Harnett County
420 McKinney Pkwy
LILLINGTON, NC 27546
Phone:
Fax:

SUBJECT: BRES2207-0025
BUILDING RESIDENTIAL

Here are the results of all Inspections located at **174 BAYLES RD:**

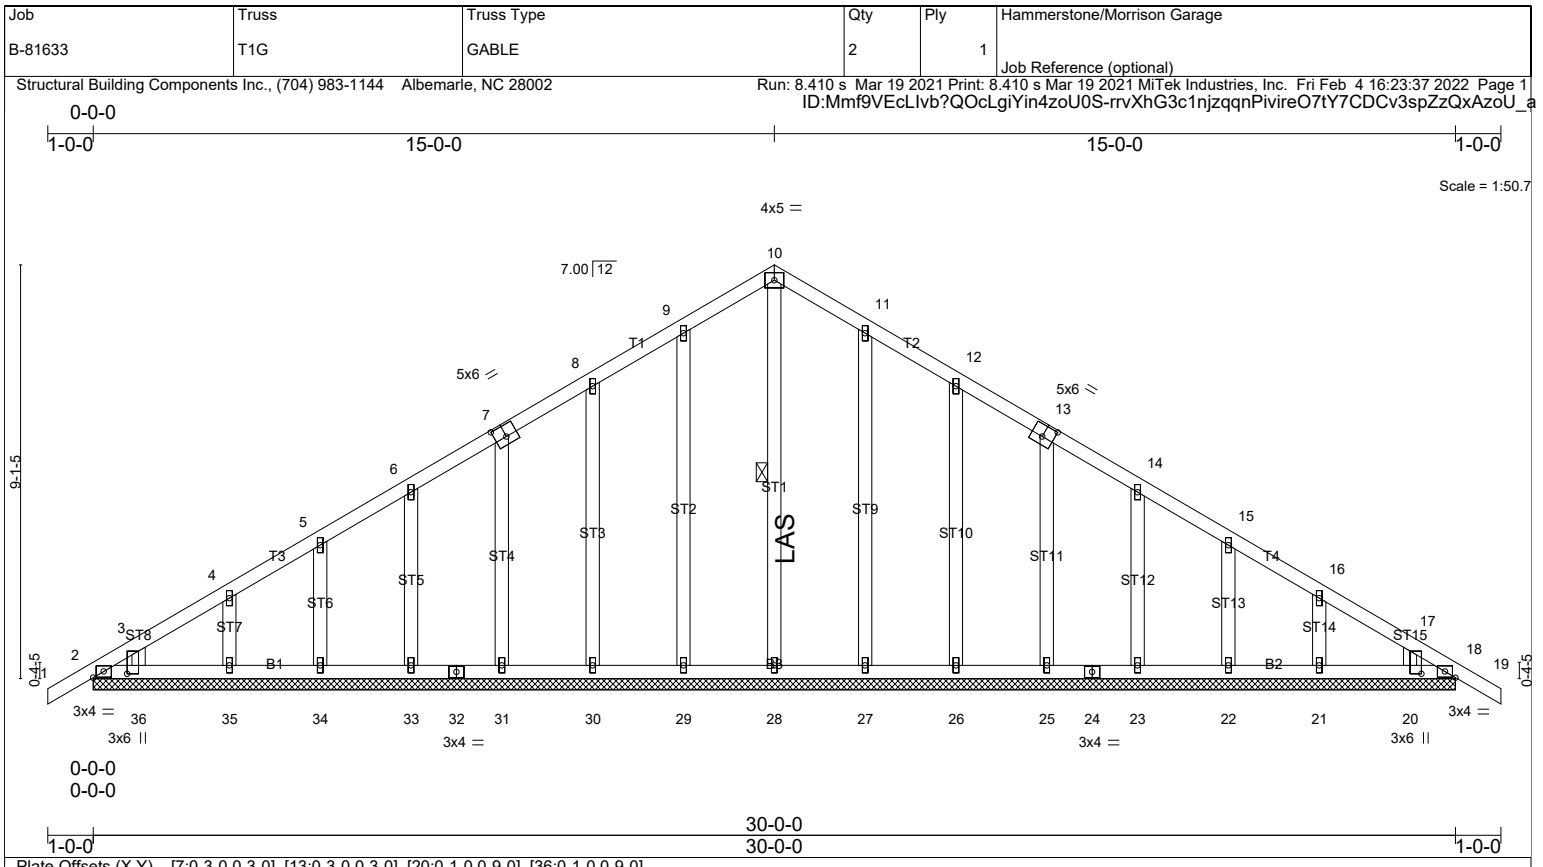
Notes: Need to fire stop chase at shower Missing air barrier at shower Missing toilet flange Missing anchor bolts both side of door left rear Missing baffles if you are insulating it. Missing anchor bolt left side of door on the right side Missing portal framing per code on garage door Missing mail guard bottom plate of panel Missing hangers on joist Need to secure house wrap per spec. Rear of garage Storage Room ceiling was covered at time of inspection Missing truss drawings

Notes: Please see notes from failed rough in
Need to have cs16 strapped code and 2(1/2 " bolts with 2x2 square washers) for portal framing right side wall facing garage door Need drawing for trusses
